TR 010018 - 10030881

Deadline 2 Representations

A14 Cambridge to Huntingdon Improvement Scheme

Representation No. 487

Drawing title: **RIGHTS OF WAY & ACCESS PLANS REGULATIONS 5(2)(k) & 5(2)(c) SHEET 10 OF 28**

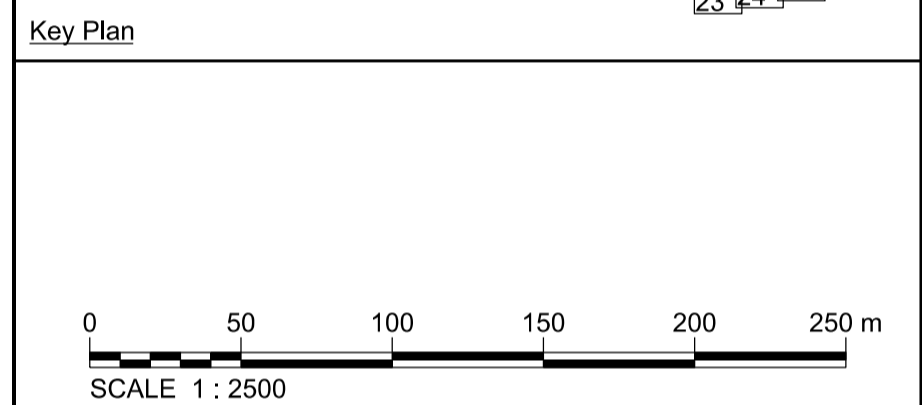
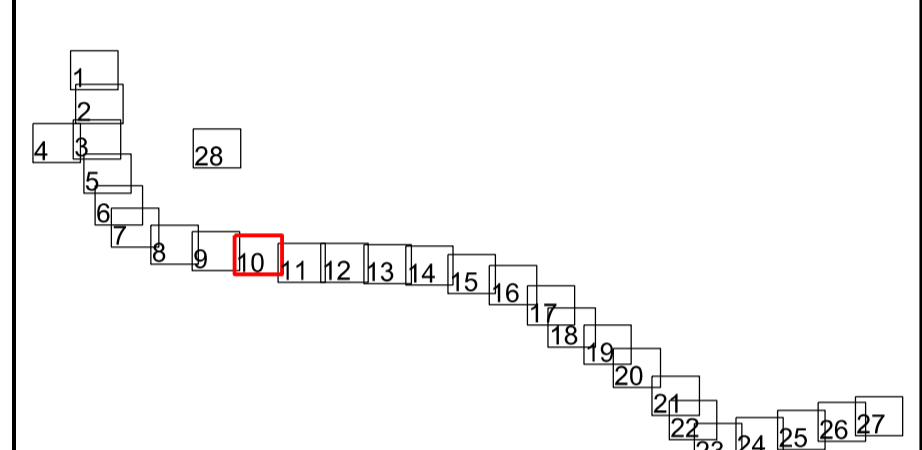
4. The effect of the scheme will be to serve land south of plot 10/7a from the balance of Corpus Christi Farm. Access will be provided from the Corpus Christi Accommodation Bridge, General Arrangement Sheet8. Currently no access has been provided to our clients severed land south of the road (see also Rights of Way and Access Plan Sheet 9).
